**From:** Zac Denton  
**Sent:** 05 October 2017 09:36  
**To:** [REDACTED]  
**Subject:** FP/199/17/T

I have just received Arboricultural comments regarding your application for tree surgery at 6 Ceres Place, Felpham.

Garden of 6 Ceres Place.

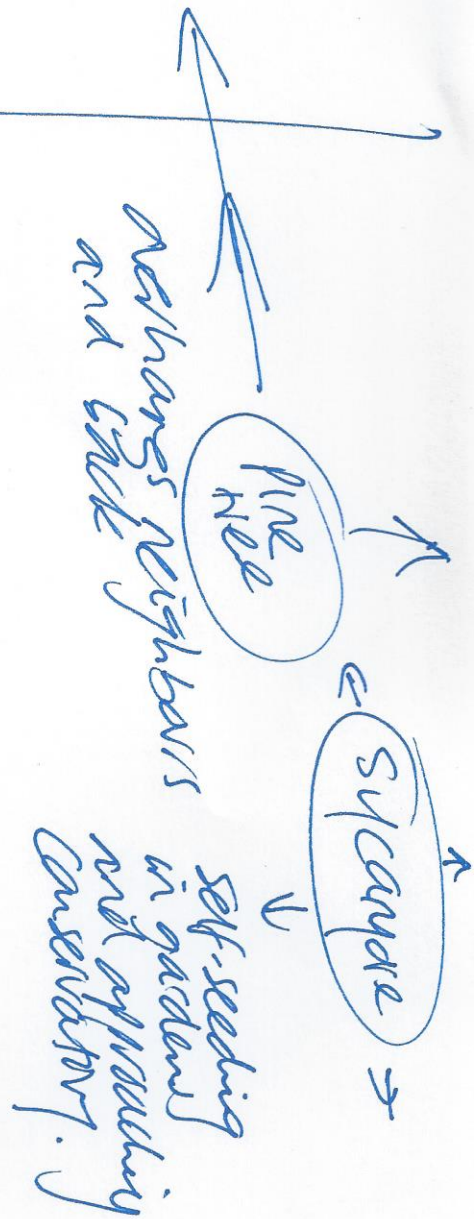
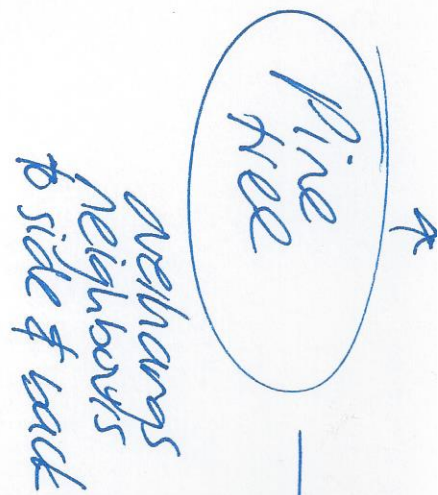
As it stands the application is set to be refused as the tree officer believes that the reduction of the pine trees is totally unacceptable.

If the reduction of the pines trees was removed from the proposal, then the application would be able to be approved. (As it would only related to the felling of the Sycamore which is acceptable)
